Application number: 2025/92897	
What is the application for?:	Erection of two storey rear and side extensions, single storey front extension,
Address of the site or building:	49, Bank End Lane, Almondbury, Huddersfield, HD5 8ES
Postcode:	HD5 8ES

Type of comment: An objection	
Do you wish your comments to be published on the website anonymously?	No
Planning Application number: 2025/92897 49, Bank End Lane, Almondbury, Huddersfield, HD5 8ES

title  
Elevations - As Proposed

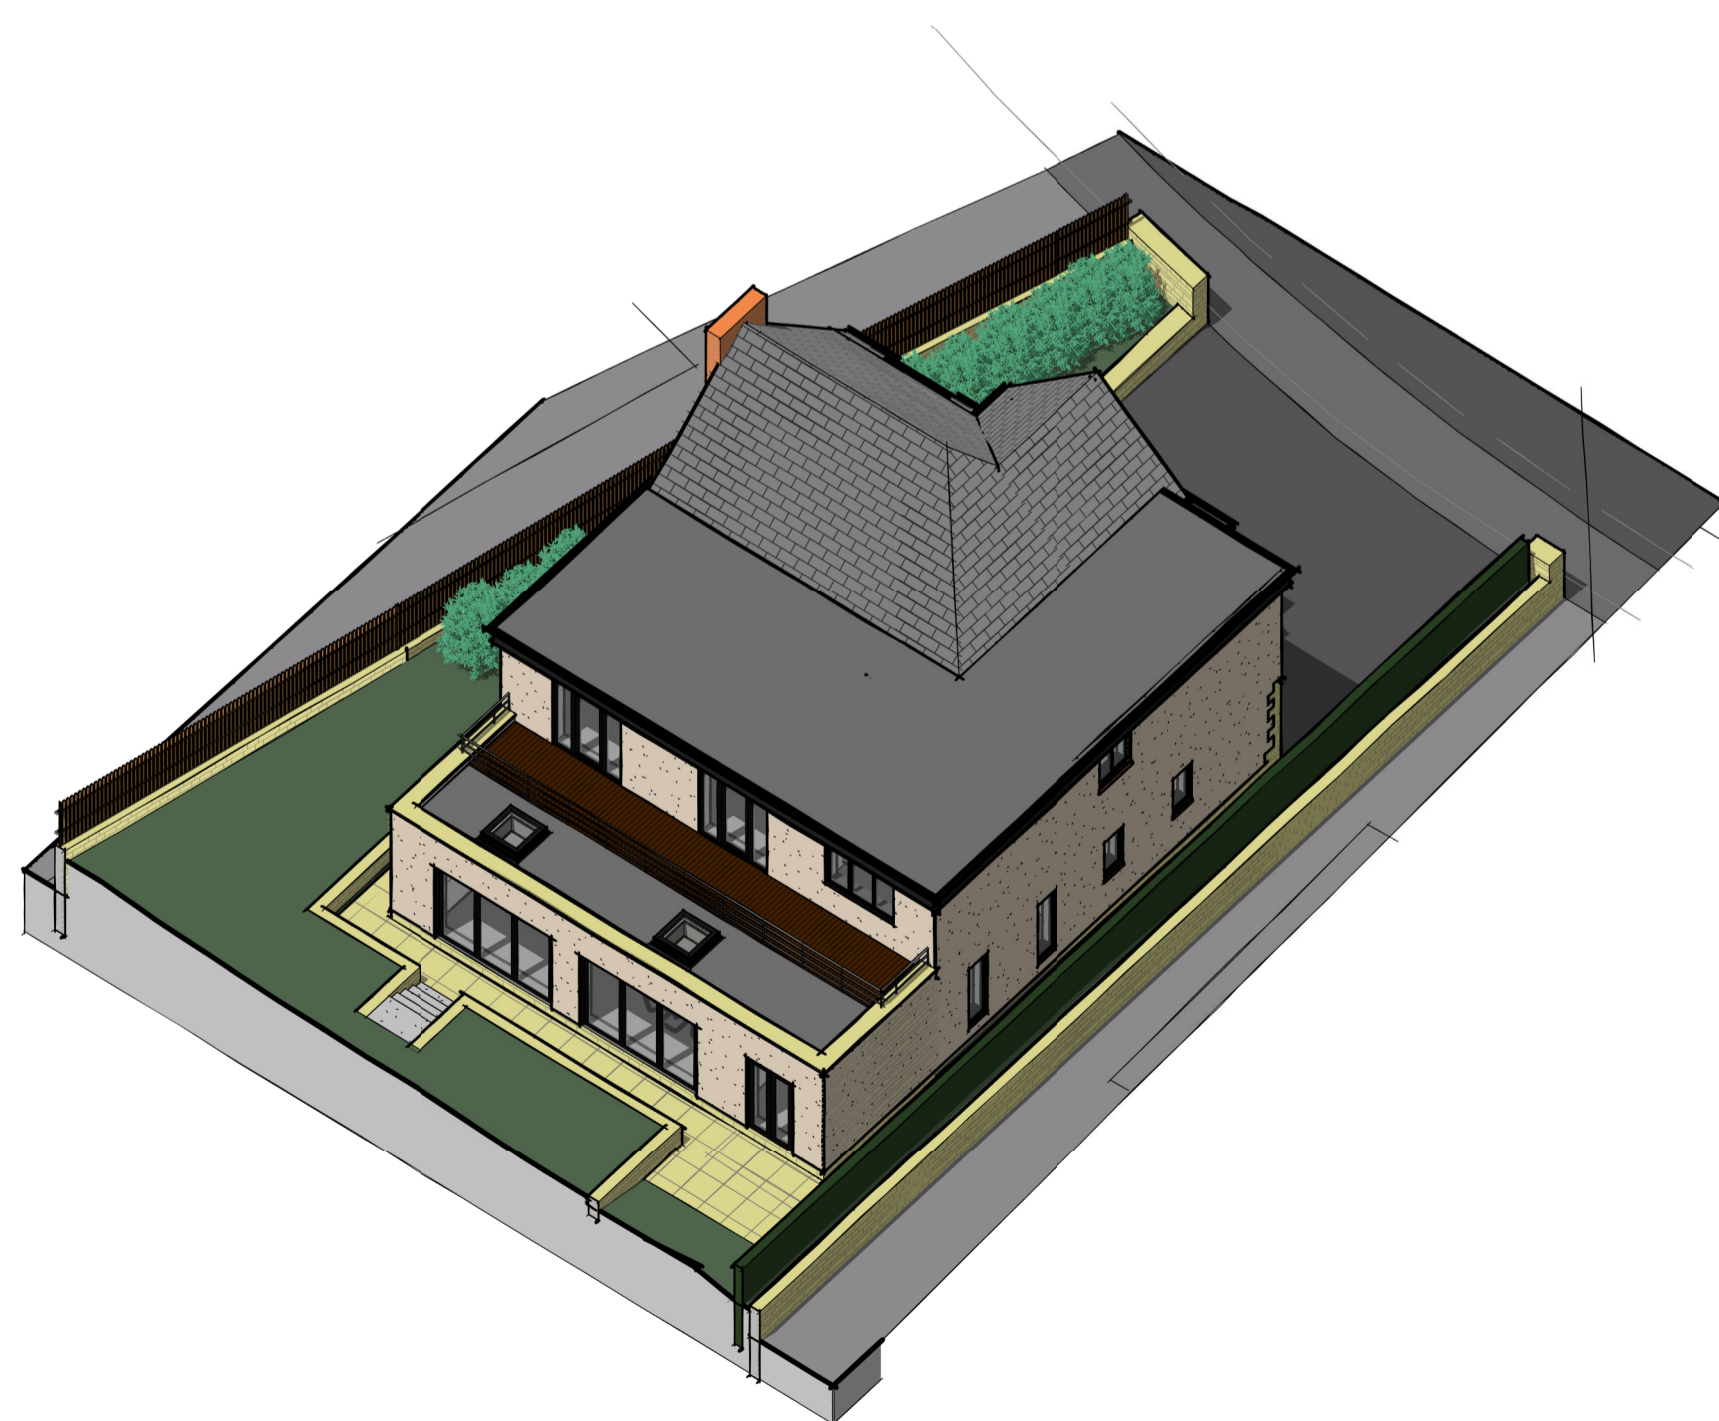
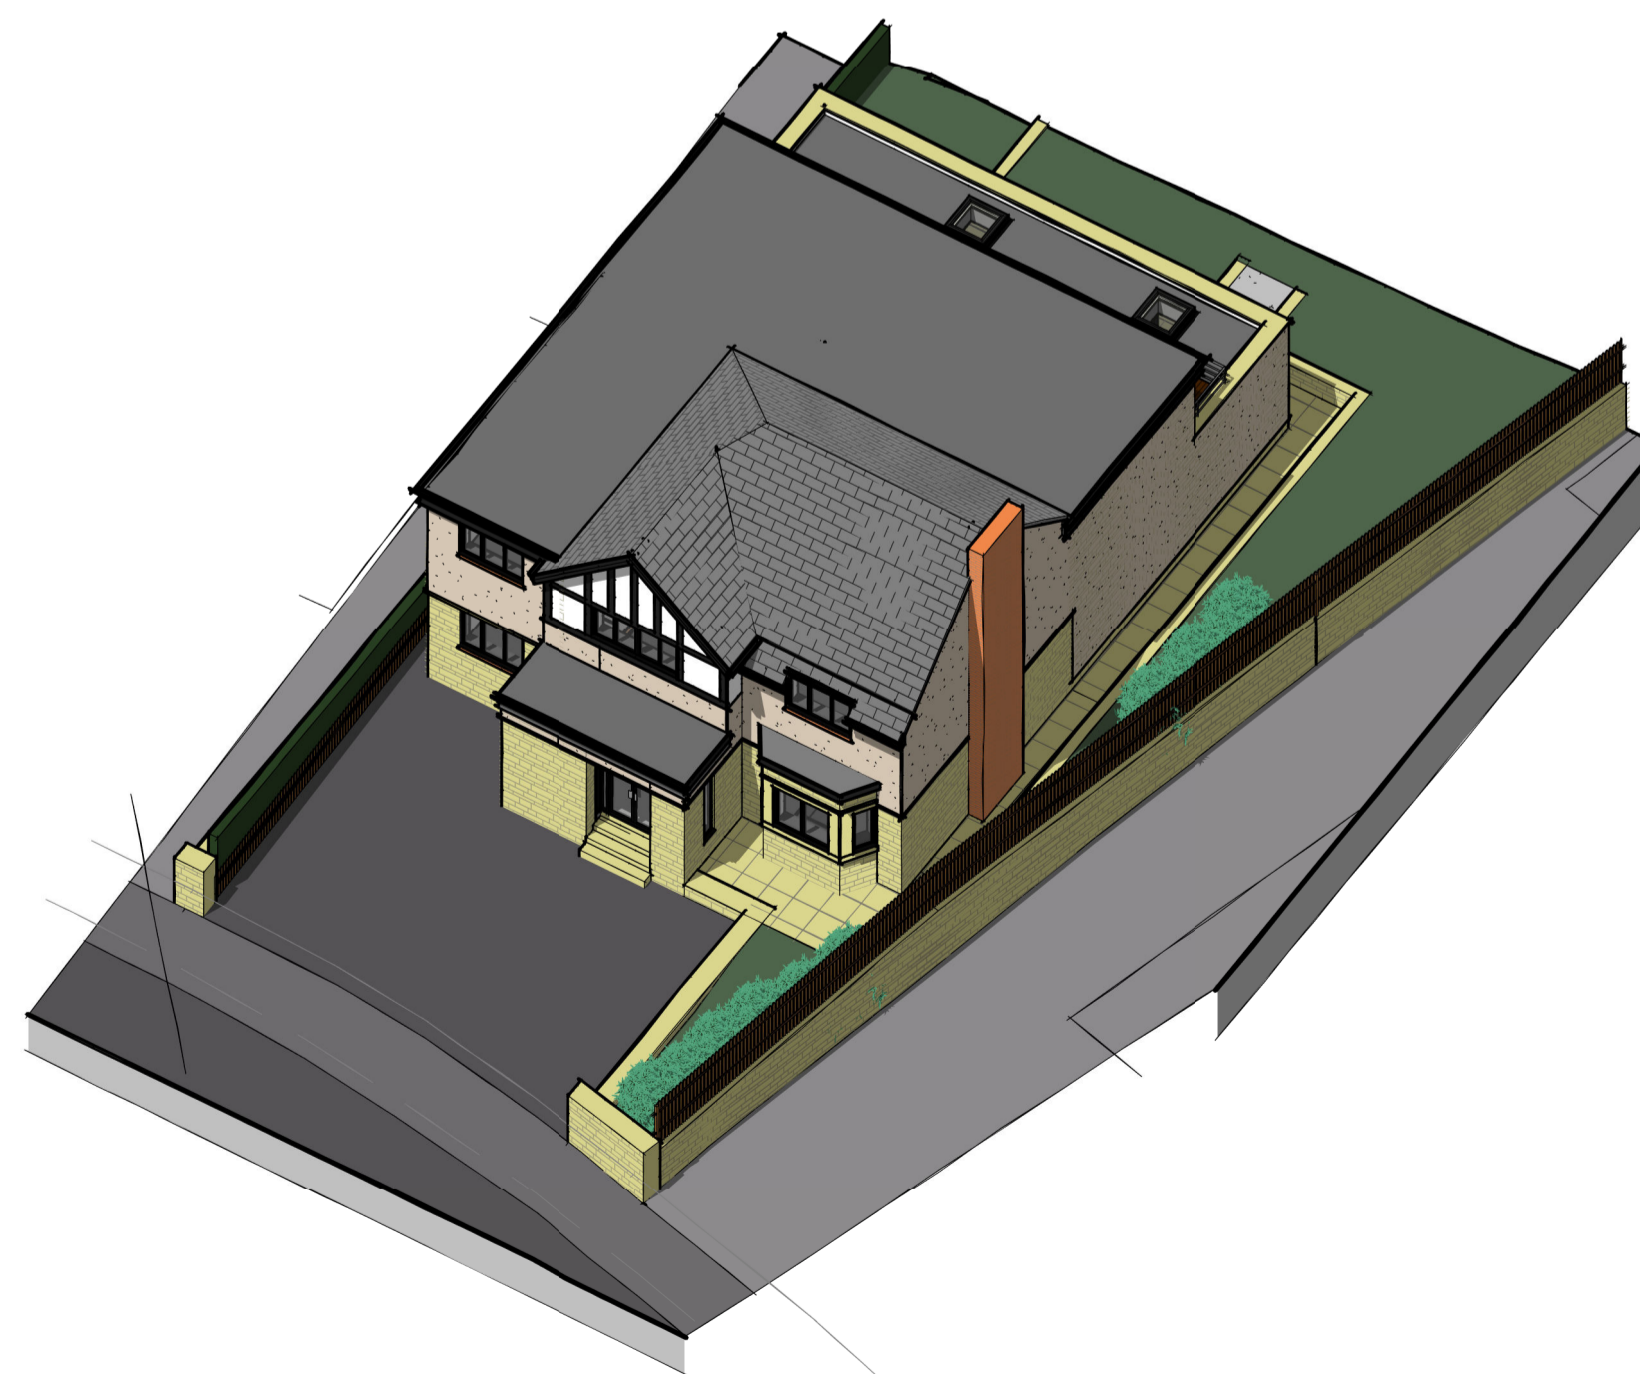
- The rear extension whilst as a single story would have been acceptable, to now add a balcony, which has the potential to invade the privacy of neighbours is unacceptable.

- The wall of the side extension on the driveway will block out light to both available light sources to the dining room of number 47.
- Reducing the available parking space by adding the side extension will also cut down on the available car parking space. One only has to walk past this house to see that the occupants/ visitors regularly park on the pavement, so if they find that the present parking on the driveway is insufficient how are they going to address that when there is little or no driveway. This is not a recent development. We have often visited long before any immediate work has been carried out to see a vehicle parked on the public footpath. The proposed new building down the drive will mean less parking, and the provision of the parking at the front of the property is inadequate. When the porch is built, there will be even less availability for parking and a five bed roomed house needs more space for vehicles than the two neatly drawn cars seen on the plans. Being situated just above the significantly steep drop down on the hill, to park on the pavement anywhere is both inconsiderate, unacceptable and dangerous but particularly so in this location. Having grown up \_\_\_\_\_, I know how dangerous this road can be, particularly in adverse weather conditions.

- Whilst permission has been given to other local properties to extend, none has been granted anything on the scale of the proposal. This proposed plan is just far too big.
